City of Albuquerque
Stormwater Construction Site
Inspection Report

Project Name and Location	Guardian Storage 3600 Bosque Plaza Lane		
Site Contact Name & Agency	Paul Hedger Guardian Storage	ESC File No. NPDES ID No.	E12 E006E NMR10010K
Date of Inspection	2-4-19	Start/End Time	1:10/2:00
COA Inspector Name	Curtis Cherne, Stormwater Quality		
Describe Present Phase of Construction	pouring slabs, exterior of bldg		
Type of Inspection:	<input type="checkbox"/> Regular <input type="checkbox"/> During storm event <input type="checkbox"/> Post-storm event (> 0.25 inch) <input type="checkbox"/> 311 / Complaint Response <input checked="" type="checkbox"/> Follow-Up

TITLE: GUARDIAN STORAGE EROSION & SEDIMENT CONTROL PLAN

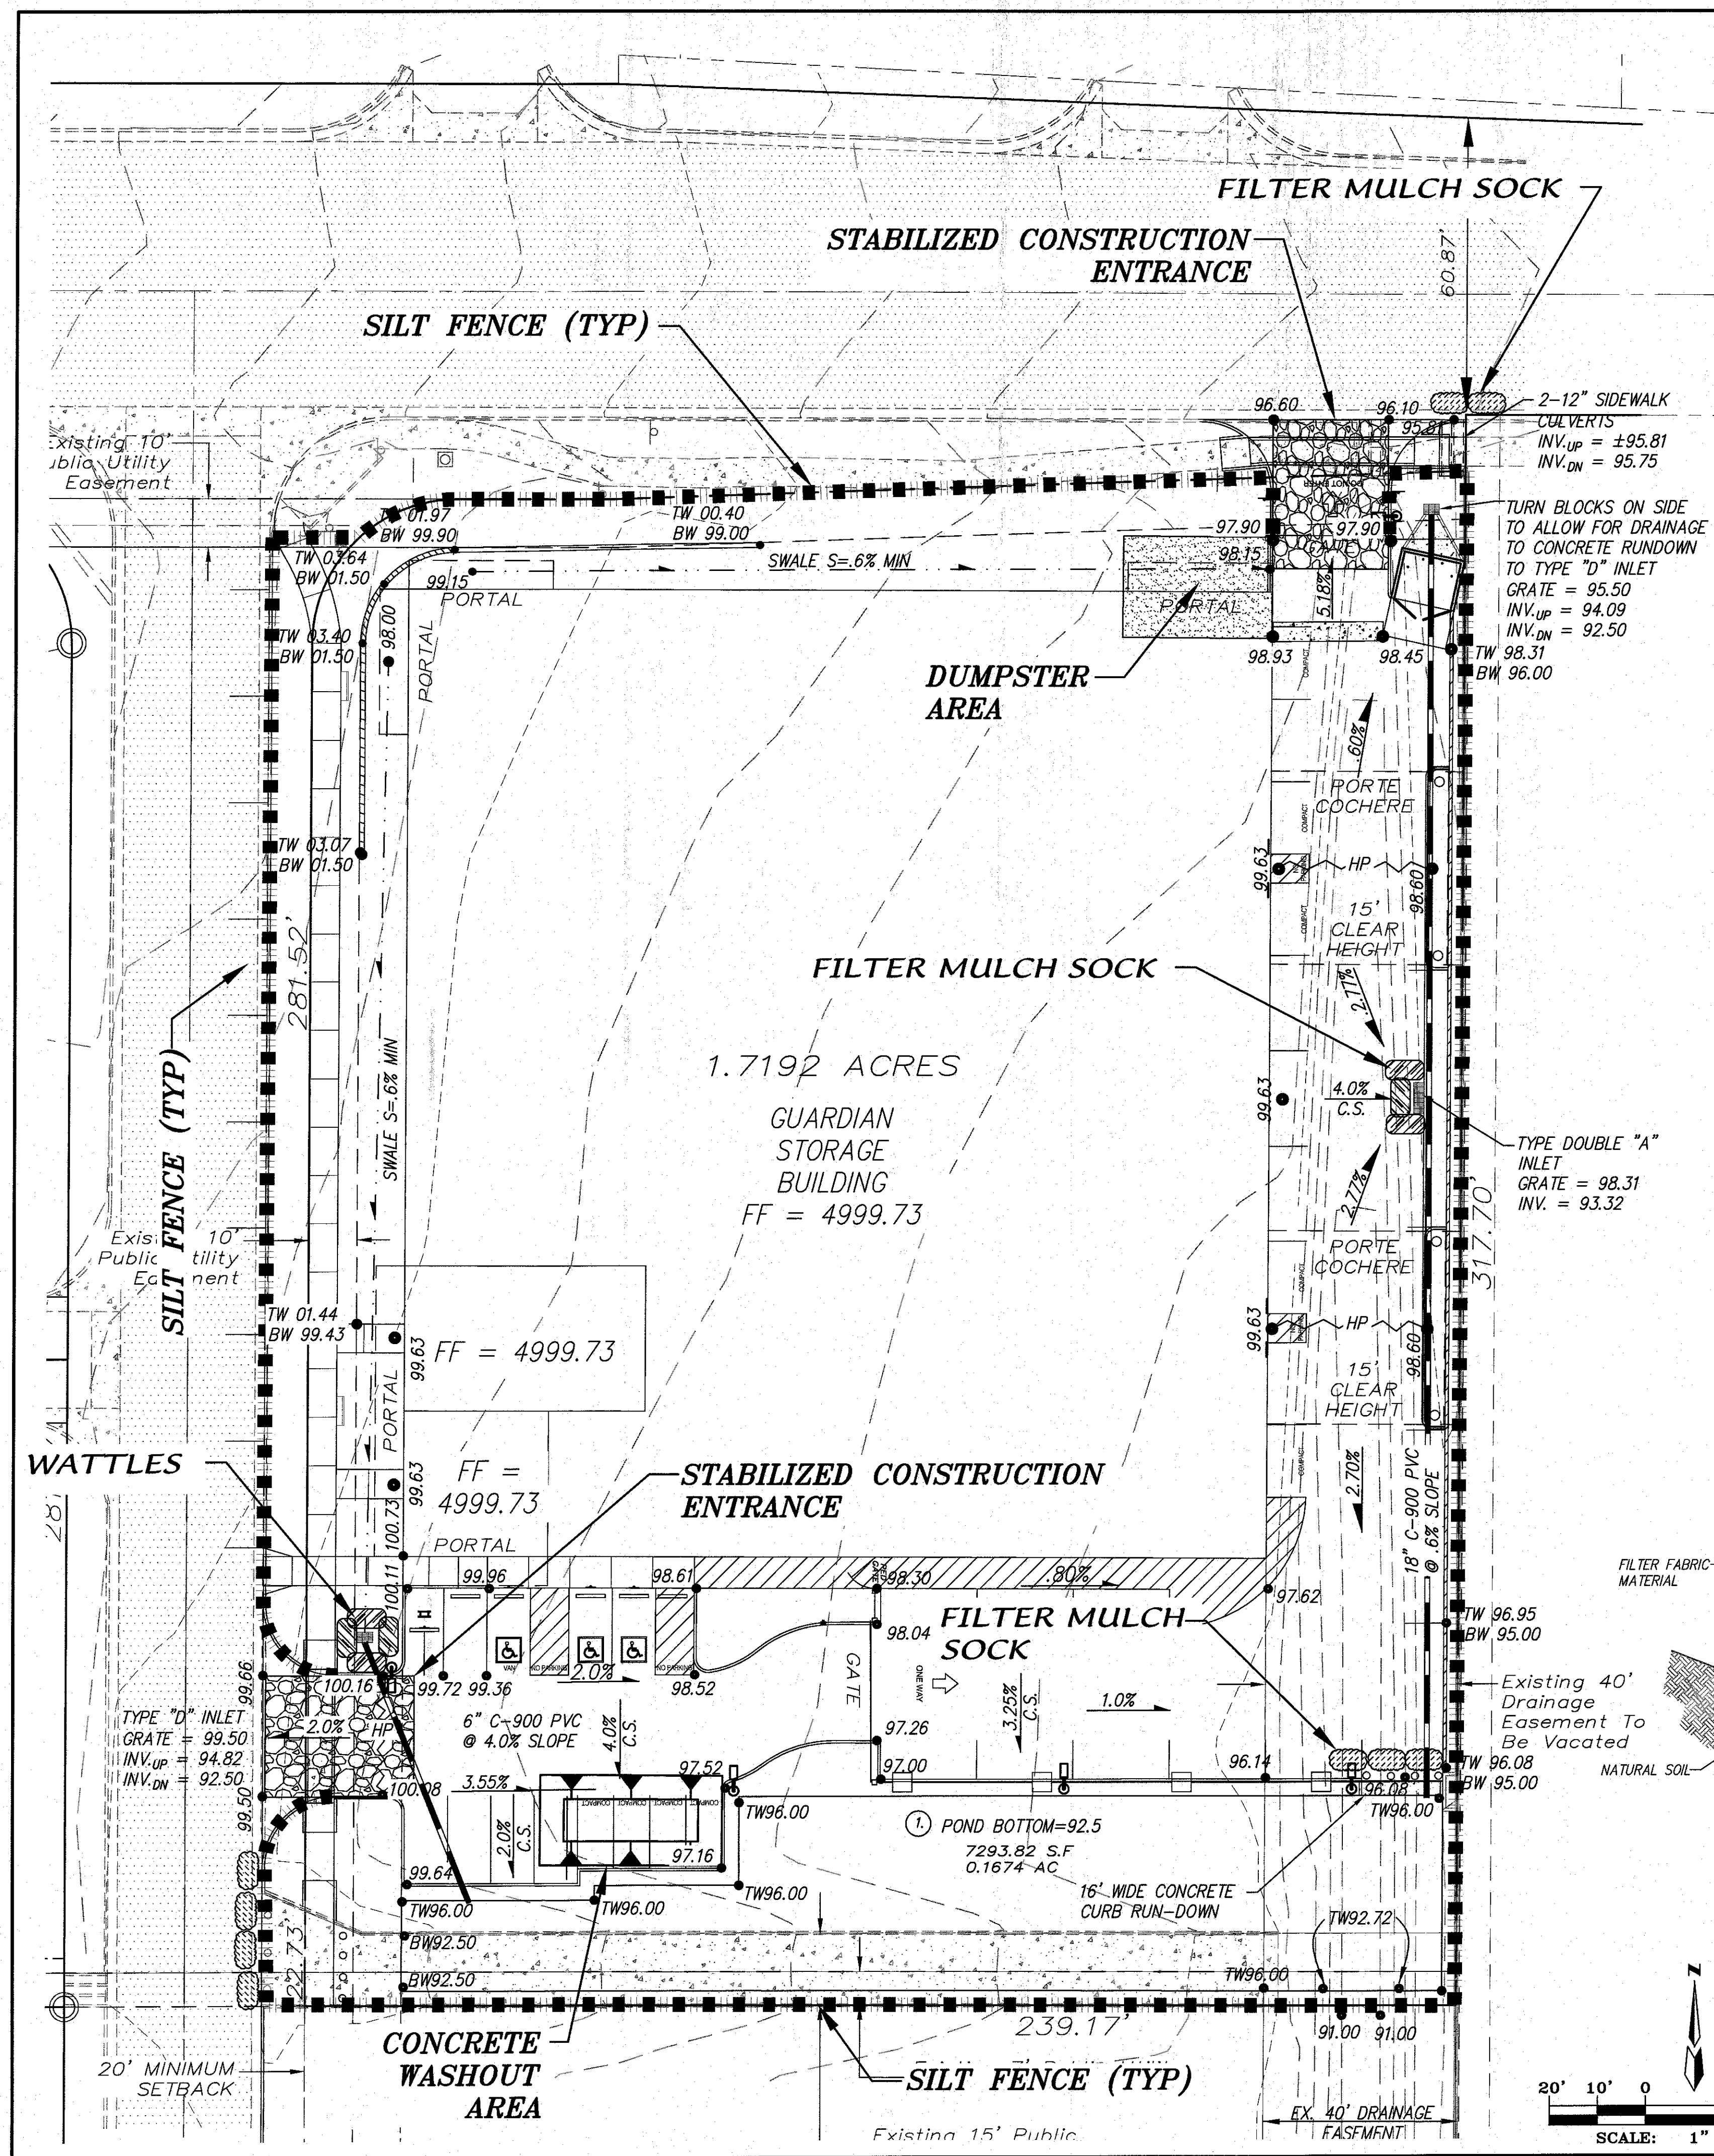
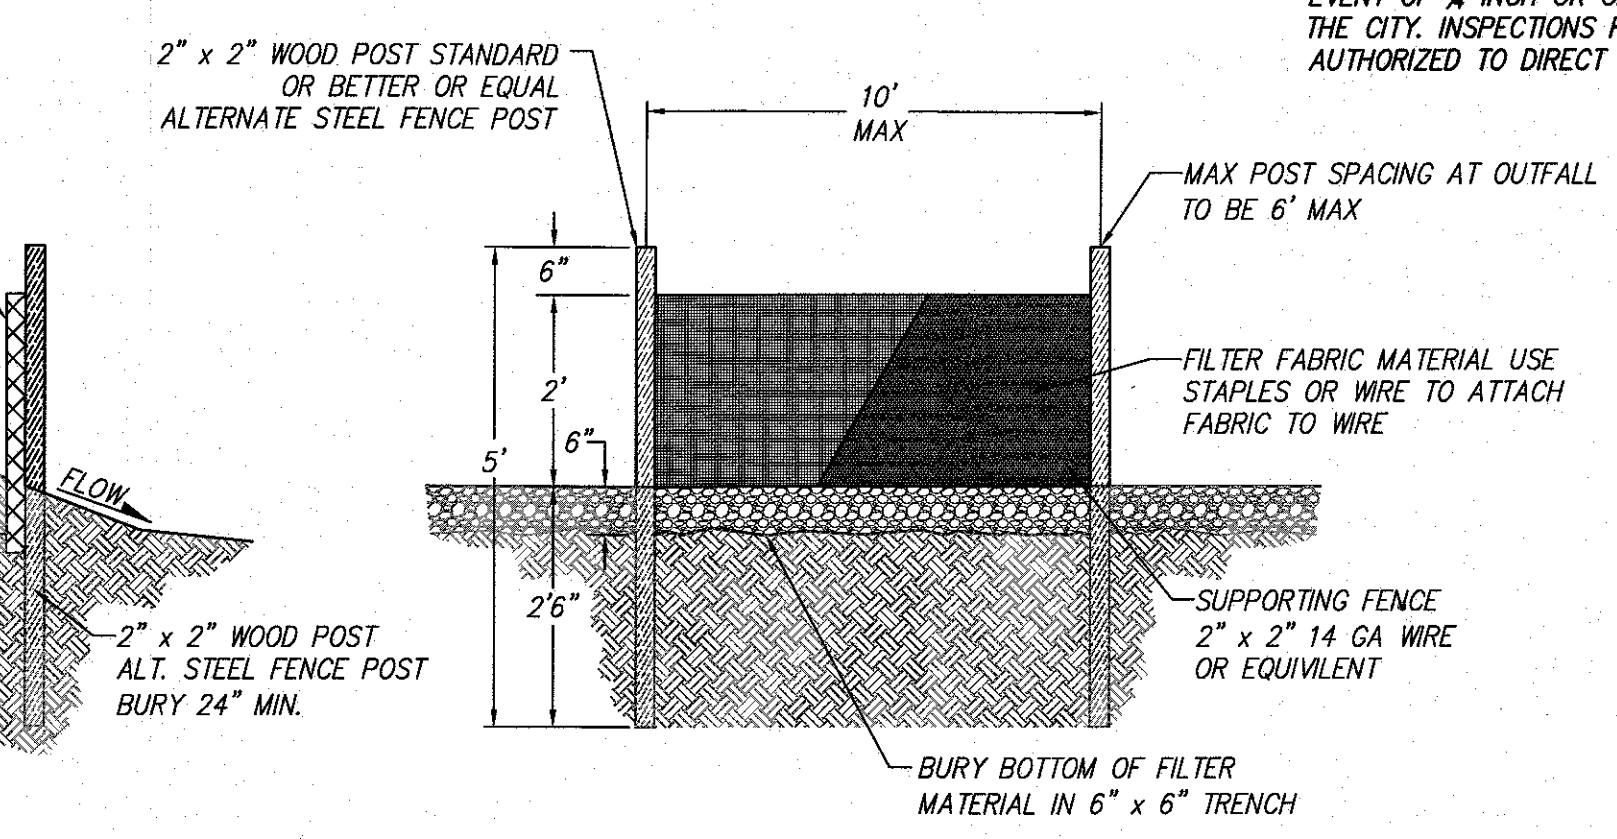
CGP ¹ Section	BMP / Activity	Maintenance or Corrective Action Required	Location and Notes
1.5	Post a Notice		
2.2.1	Provide and maintain Natural buffer when Waters of the US < 50 ft		
2.2.3	Sediment control along any perimeter	✓	gaps in silt fence north side
2.2.3	Sediment control along any perimeter	✓	silt fence requires maintenance north side
2.2.3	Sediment control along any perimeter	✓	track-out into La Orilla
2.2.3	Sediment control along any perimeter	✓	sediment in La Orilla
2.2.3	Sediment control along any perimeter		
2.2.3	Sediment control along any perimeter		
2.2.3	Sediment control along any perimeter		
2.2.4	Minimize sediment track-out	✓	no track

2.3.3	Fuel, oil, hydraulic fluid, petroleum products and chemical storage	✓	oil dripper in the orilla
2.3.3	Construction and Domestic Wastes	✓	wash-out - numerous

2.3.3	Construction and Domestic Wastes	✓	weather-seal on ground
2.3.4	Washing Applicators used for paint, stucco, concrete, etc.	✓	no acceptable facility

Maintenance or corrective actions are to be completed within 7 days.
